RANCH ON SWAUK CREEK PUD QUICK REFERENCE STAFF REVIEW MATRIX MARCH 31, 2016

Project Overview	
Subject Property:	487.43 acres
Development Density:	243 lots
Uses Allowed:	Residential, passive and active recreational activities, community
	center
Preliminary Approvals:	Ordinance 2006-59

**RANCH ON SWAUK CREEK  
PHASE 1, DIVISION 1 - P.U.D.**  
PTN. SE 1/4 OF SECTION 28, T. 20N., R. 17E., W.M.  
KITITAS COUNTY, STATE OF WASHINGTON

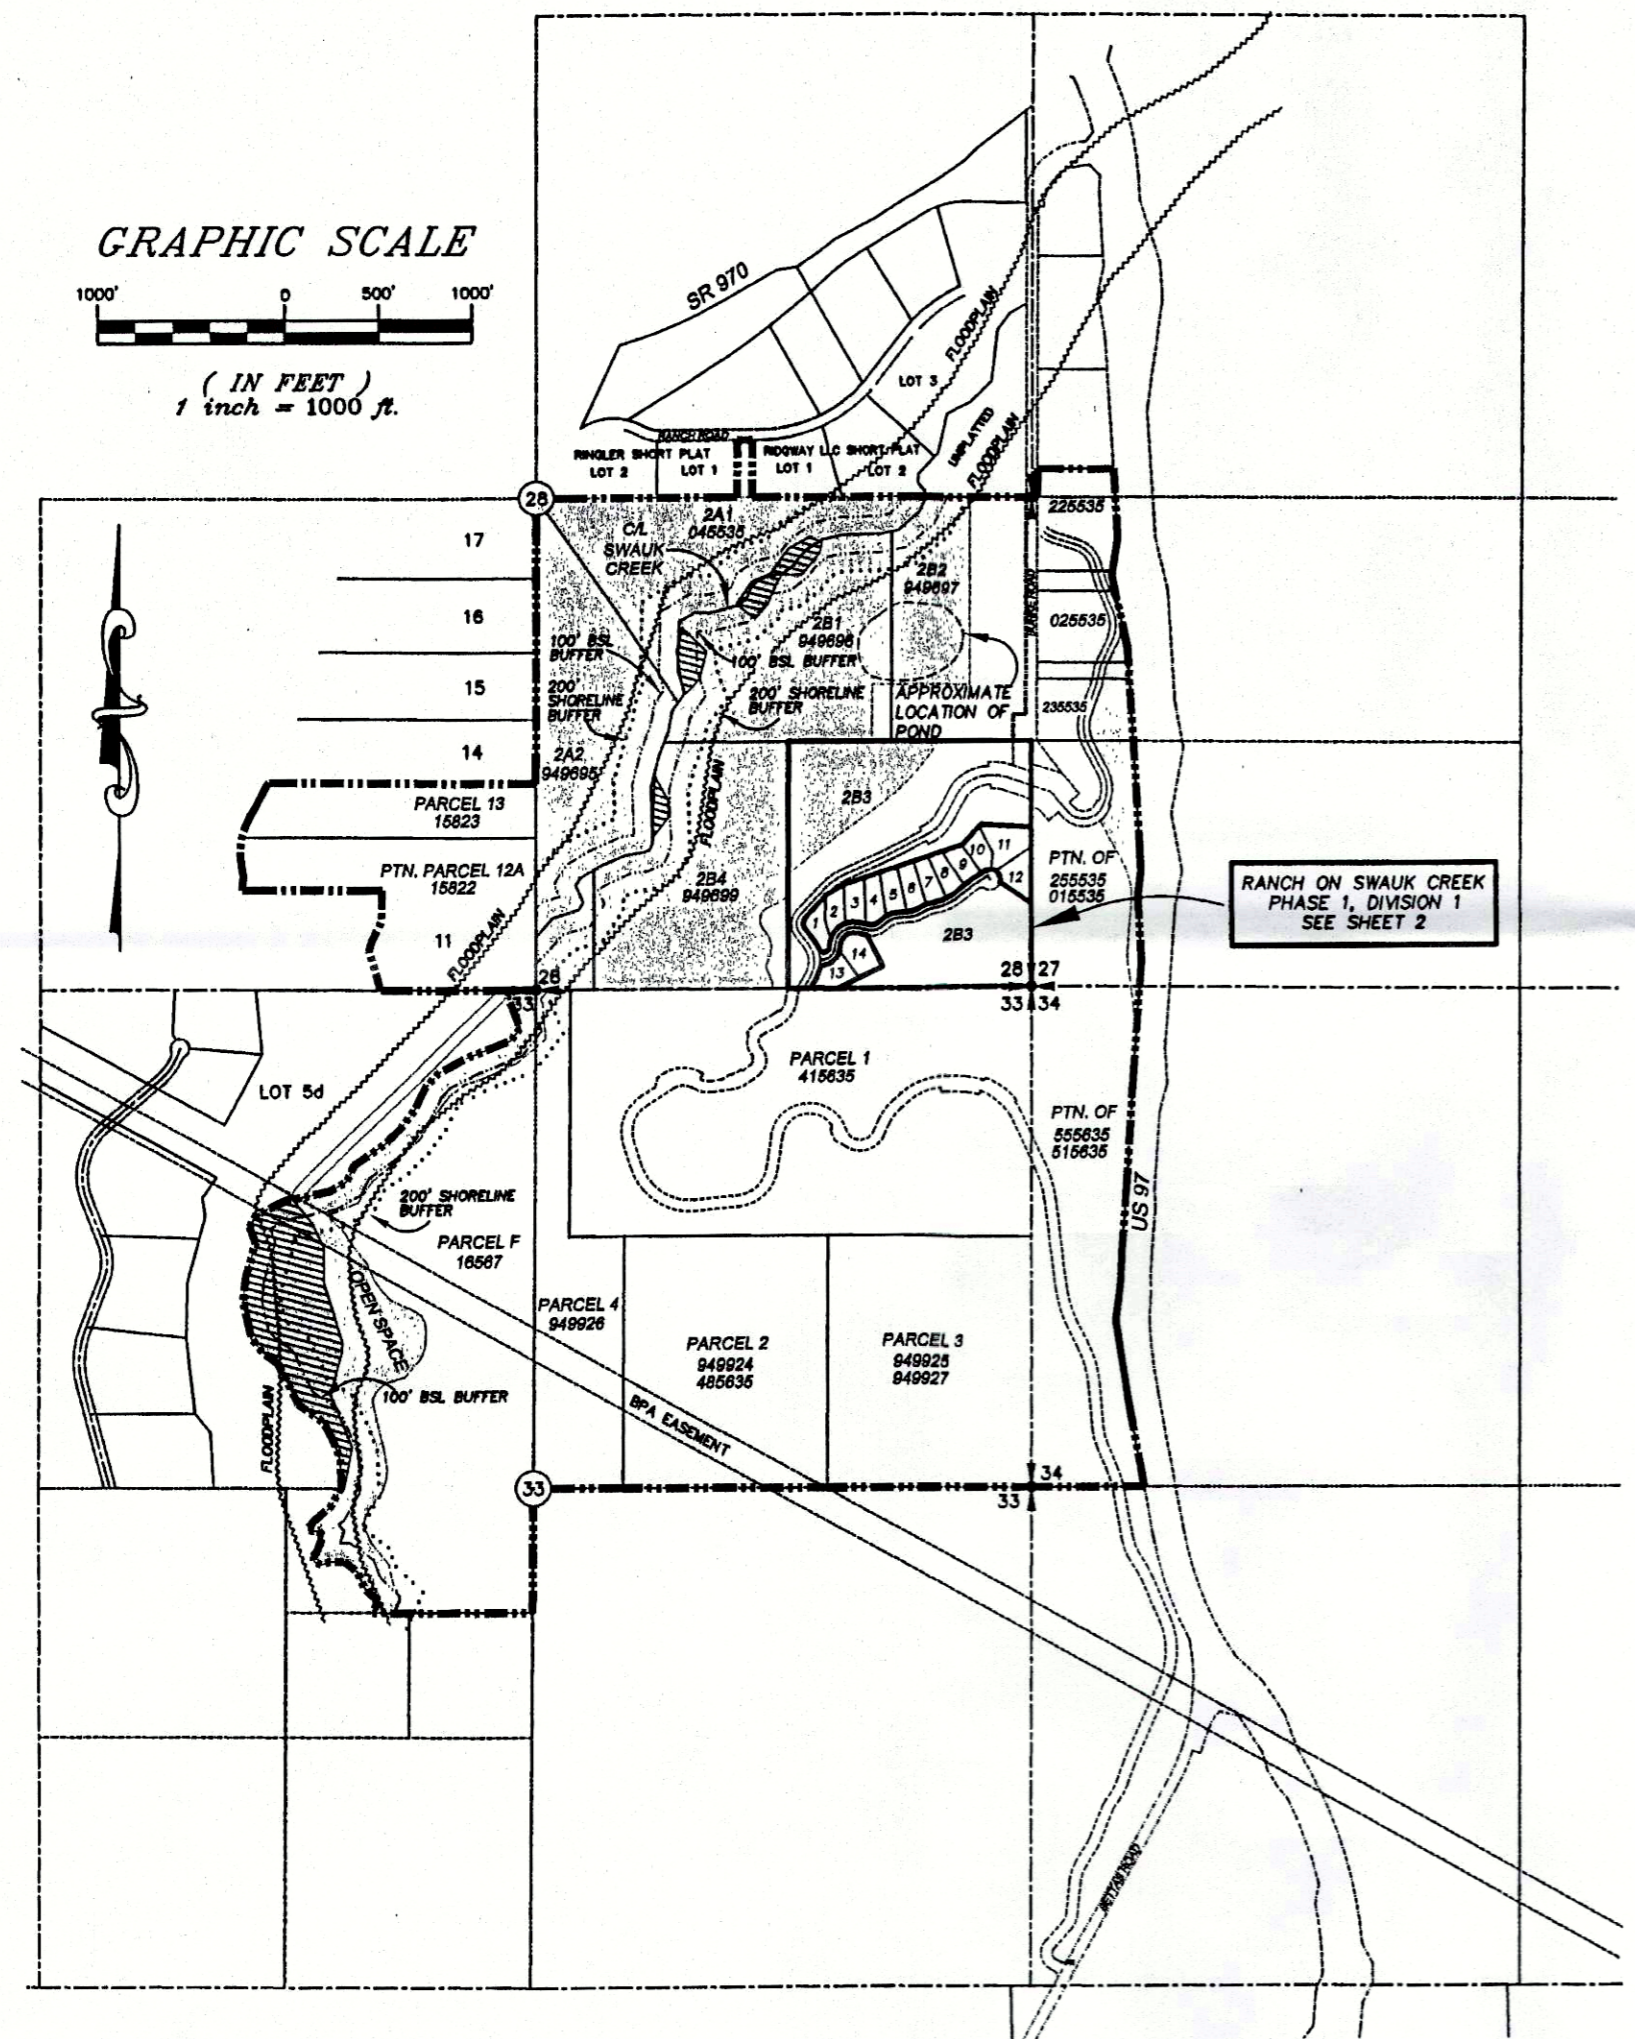
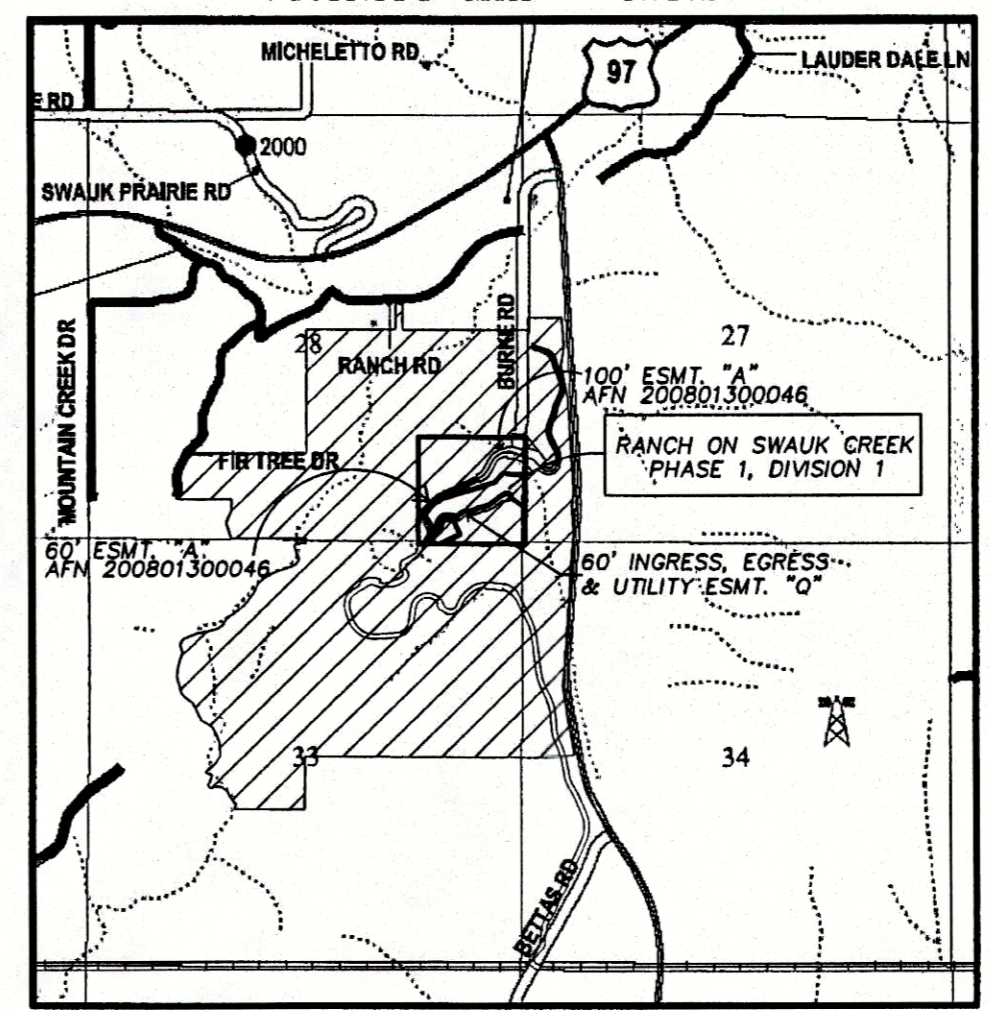
C. All development shall comply with the Kittitas County Shoreline Master Program.	Attachment C	Completed. Swauk Creek Shoreline is within the designated Open Space. Open space and buffer map was recorded as part of the Final Approval of Phase 1 Division 1 (14 lots). See Attachment C. This condition has been met.

D. Per the Kittitas County Shoreline Master Program, a minimum of 100 feet buffer for structures shall be maintained along Swauk Creek. The buffer shall be maintained by the owner or applicable maintenance associations.	Attachment C	Completed. Swauk Creek Shoreline is within the designated Open Space. Open space and buffer map was recorded as part of the Final Approval of Phase 1 Division 1 (14 lots). See Attachment C. This condition has been met.

E. A 100 foot structural setback and 200 foot setback per the Kittitas County Shoreline Master Program from the Ordinary High Water Mark of Swauk Creek shall be shown on the final mylars.	Attachment C	Completed. Swauk Creek Shoreline is within the designated Open Space. Open space and buffer map was recorded as part of the Final Approval of Phase 1 Division 1 (14 lots). See Attachment C. This condition has been met.

F. The 100 year-floodplain and determined wetlands shall be shown on the final mylars.	Attachment C	Completed. Floodplain and wetlands shown on final plat for Phase 1, Division 1. See Attachment C. This condition has been met.

C. The applicant will place a minimum of 30% of the land, 146 acres, in Open Space for perpetuity and will be designated on the final Mylar.	Attachment C	Open space and buffer map was recorded as part of the Final Approval of Phase 1 Division 1 (14 lots). See Attachment C. This condition has been met.

Illustrative Master Plan

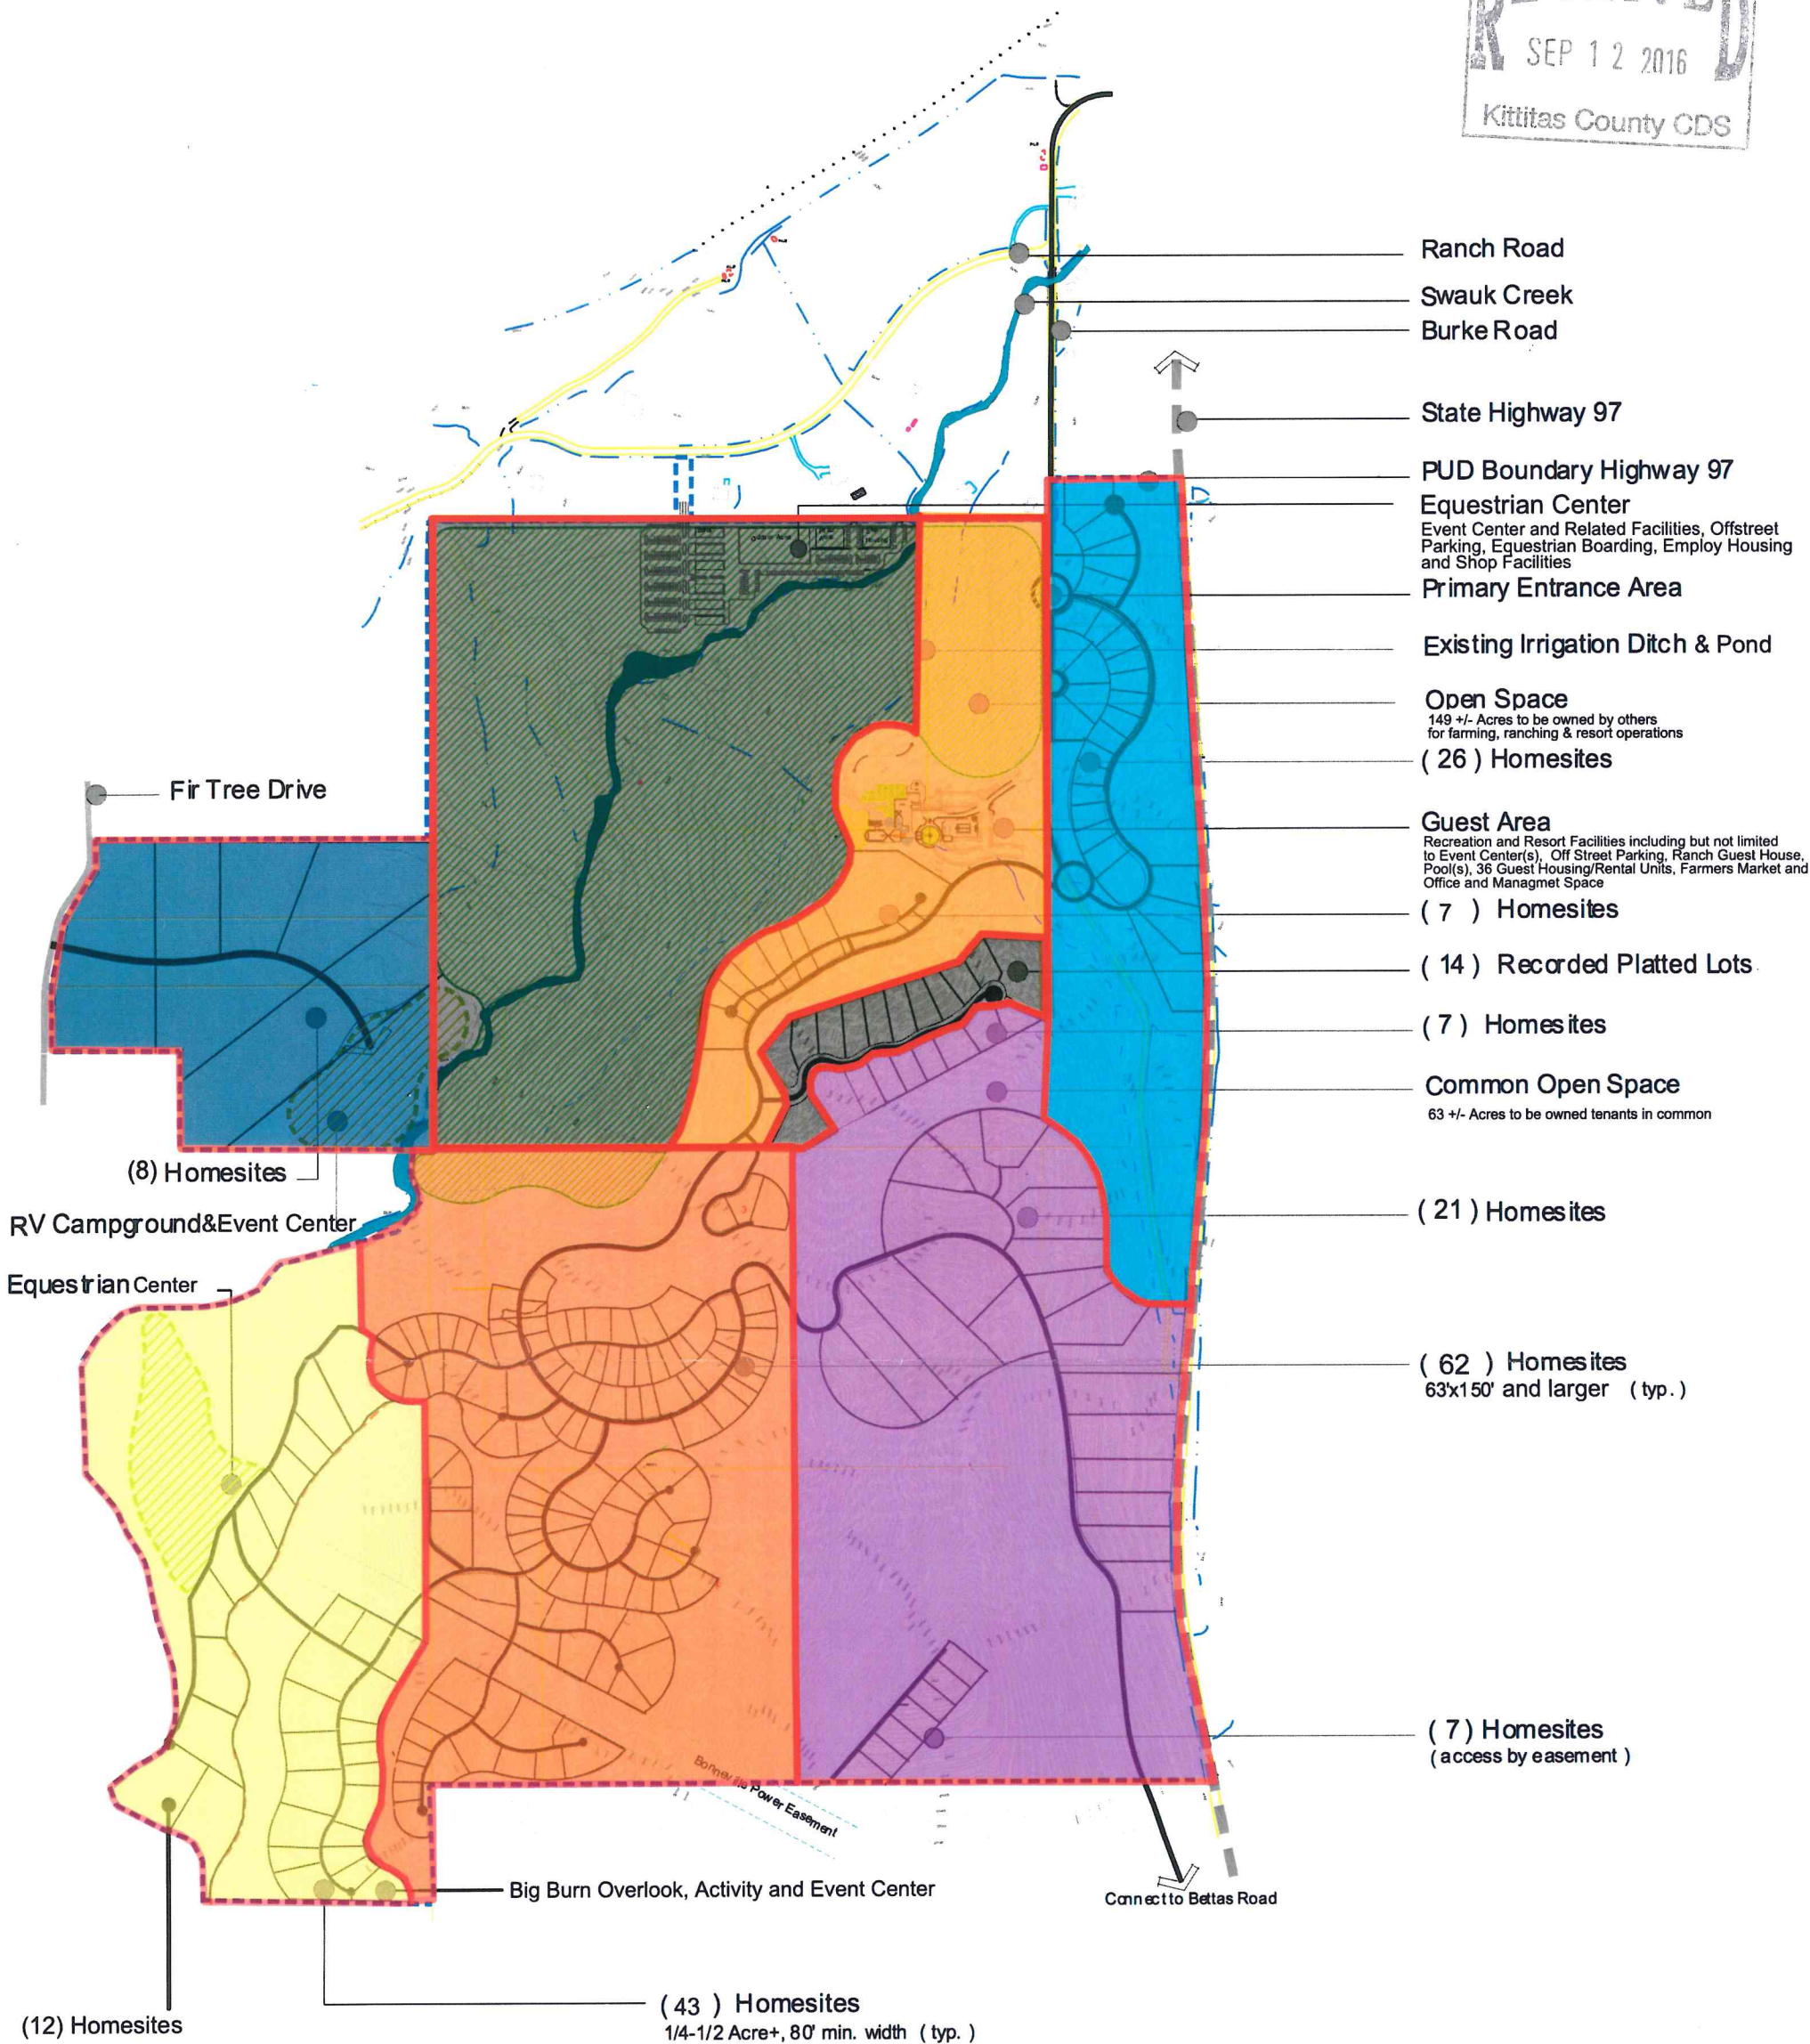
4. Location and number of off-street parking areas including type and estimated cost of surfacing;	Attachment A & E	Phase 1 – Existing barn has been updated into community center, with existing off-street parking area that will be expanded. Parking locations shown on 9/12/16 "Illustrative Master Plan." Three parking areas identified that contain an estimated 200 parking spaces each. Meets requirements of

6. The location and total area of common open spaces;	Attachment I	The 9/12/16 "Illustrative Master Plan" shows common open space areas. Recording #200811030046 formally creates 14 lots (ROSC Phase 1 Division 1) at the same time records and preserves the required 30% open space along with buffers etc. Meets requirements of KCC 17.36.040.

Ordinance 2006-59 Conditions	Documentation	Staff Comments
I. Transportation		
A. Access to US-97 for these properties will be via the Burke and Bettas Road intersections. No direct access to US-97 will be allowed.	9/12/16 "Illustrative Master Plan"	No direct access to US 97. This condition has been met.
